Longfield Solar Farm

Applicant Comments on Submissions Received at Deadline 4

Document Reference: EN010118/EX/8.21

November 2022

TITLE: Works Plan Sheet 7

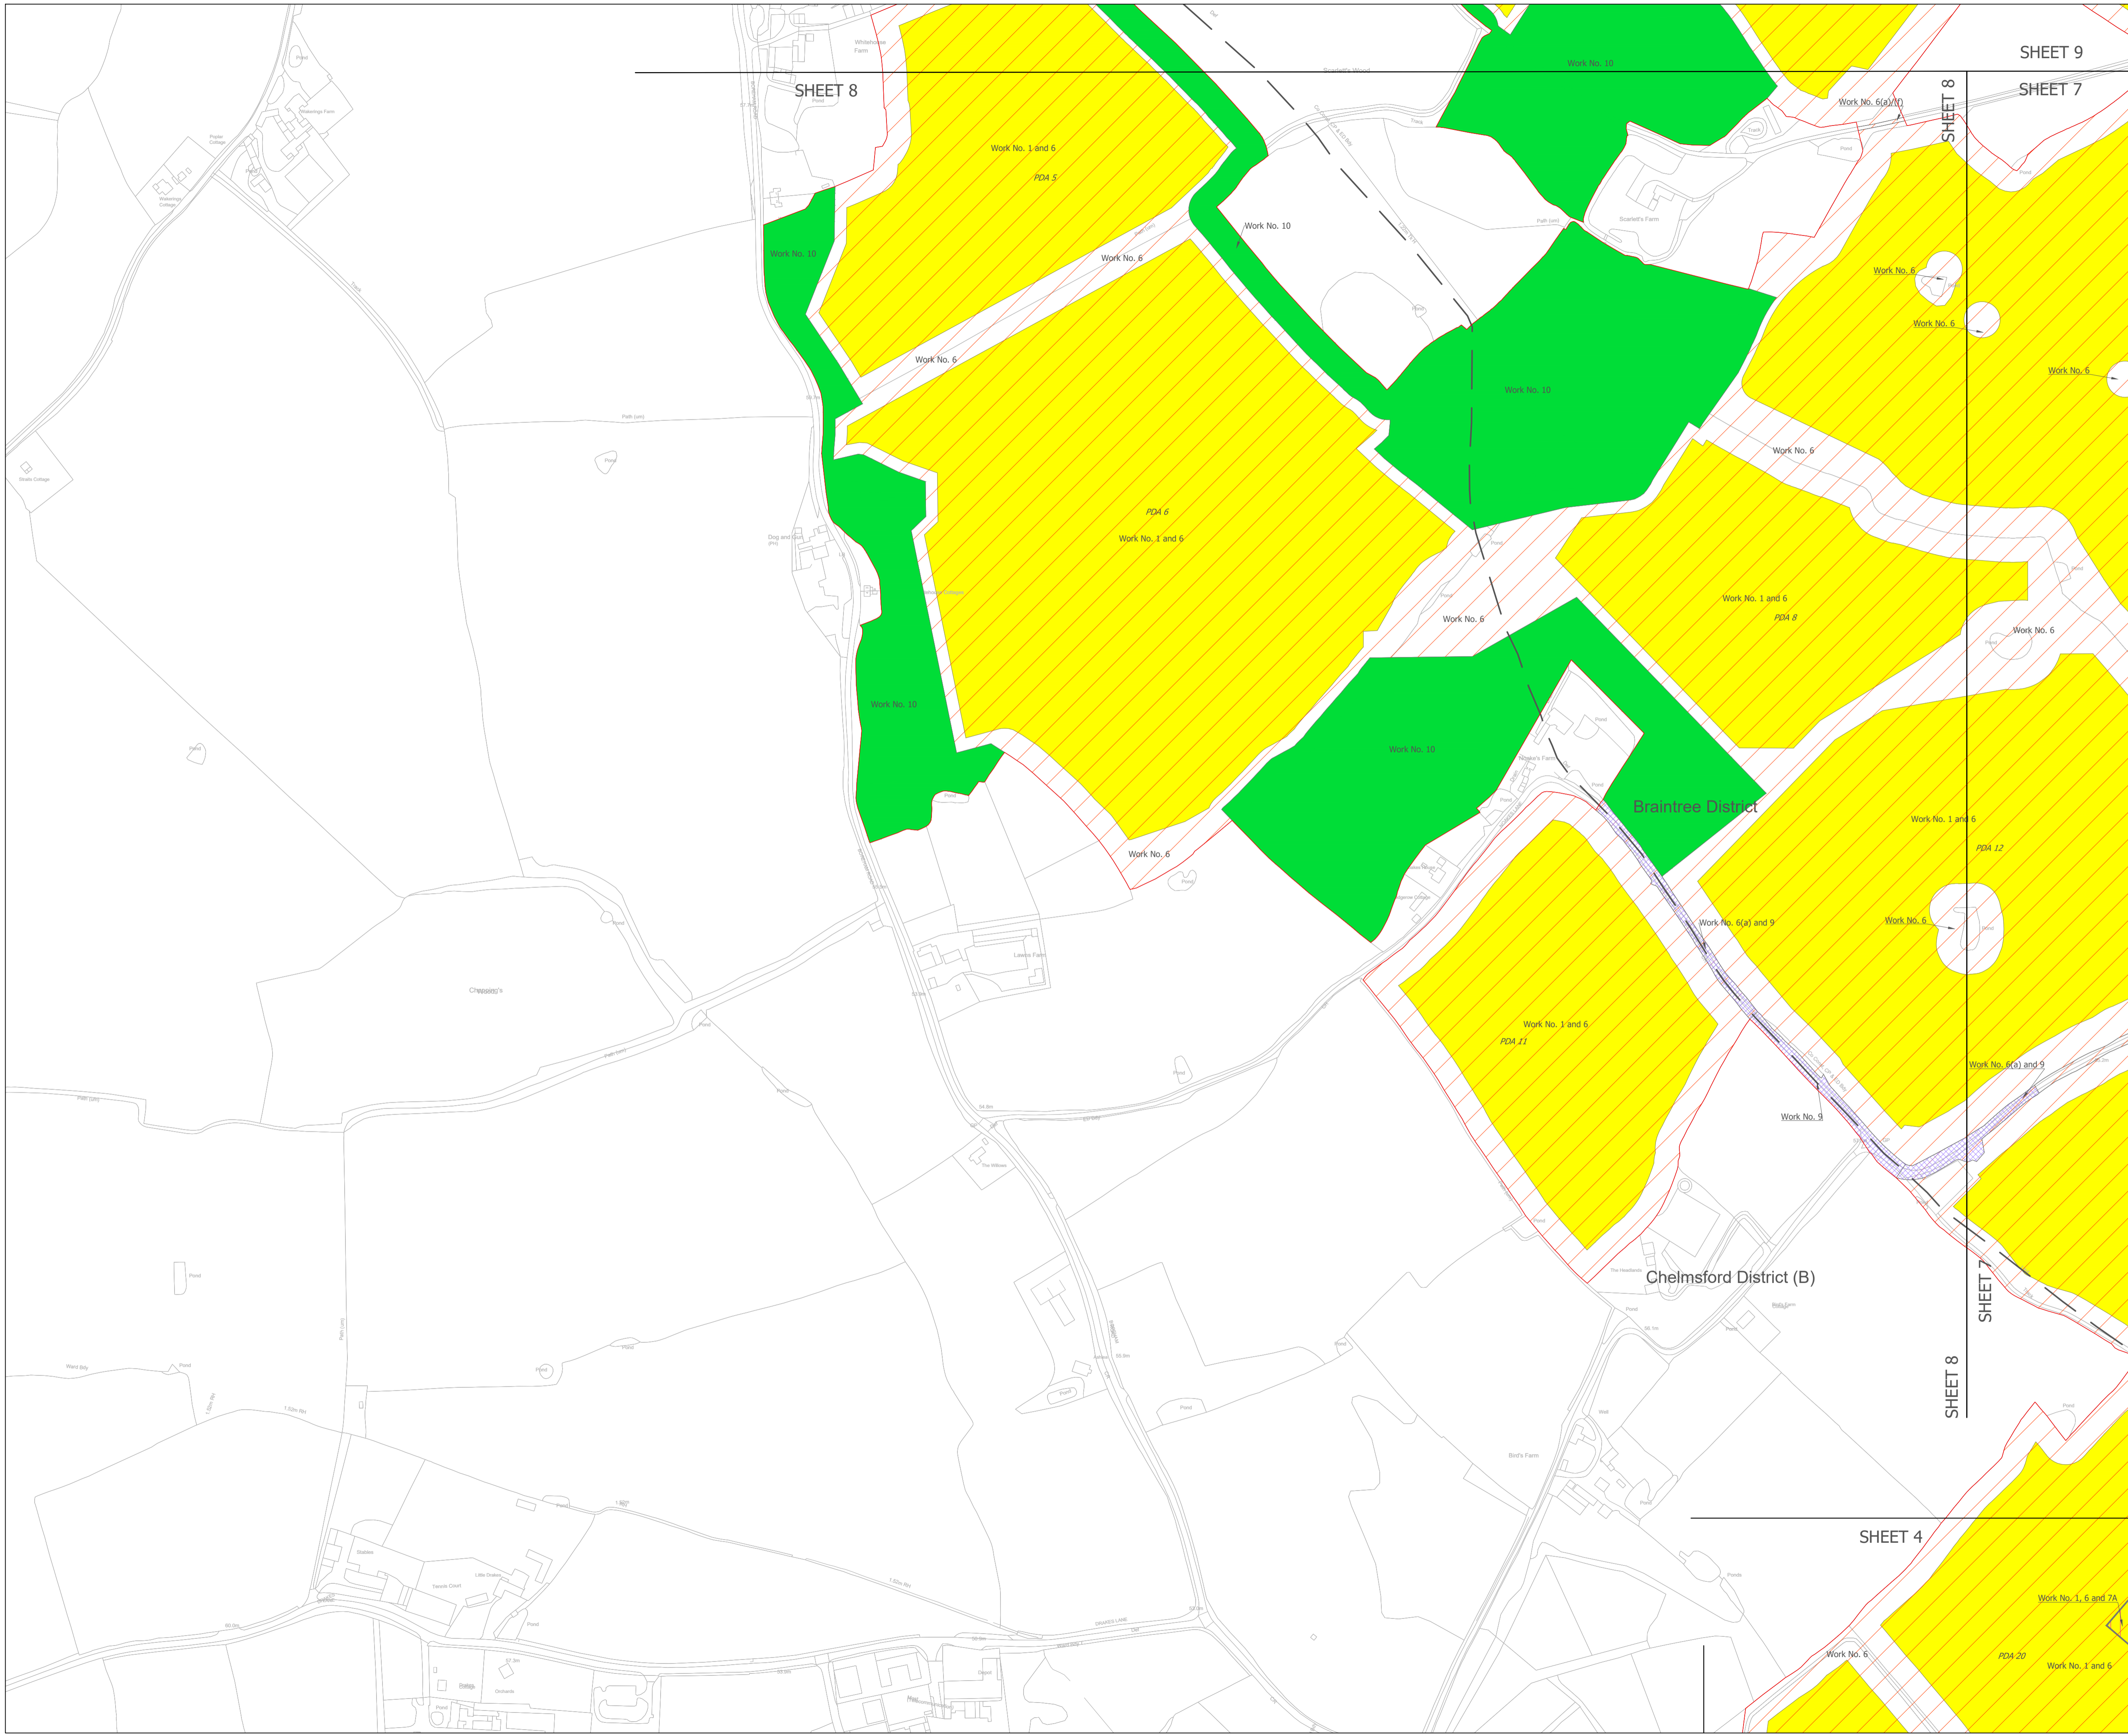
- (i) At the northern end, a connection to the permissive paths for cyclists and horse-riders, that is inside the pink wash land, could be to Rolls Farm Lane / Sparrows Farm Lane, which is a public road at the northern termination of Terling footpath 33 [113_33]. See Land Plan sheets 7 & 9.
- (ii) (ii) At the southern end the final western sections of the footpath connections to Waltham Road – Boreham footpath 18 or 19 [213_18 or _19] are outside the order limits so would require the permission of the landowner. The other connection along the cable route would also require landowner permission. See Land Plan sheets 3 & 2.

The response provided by ELAF requests that an additional permissive path is provided towards the northern end of the Order limits, connecting Rolls Farm Lane to Permissive Path 1, thereby providing access to cyclists and equestrian users (as shown in Figure 1 overleaf). However, were this to be provided, it would afford a limited increase in access to cyclists and equestrian users given the constraint in accessing ongoing routes posed by connecting footpaths (PROW 113_11 to the north and PROW 113_33 to the south).

The additional routes would also provide a very limited increase in access for cyclists and equestrian users, given the constraints posed by connecting footpaths PROW 213_19 and PROW 213_18. Given these constraints no changes to the permissive paths are proposed. It remains that, where accessible, permissive paths will be open to all users.
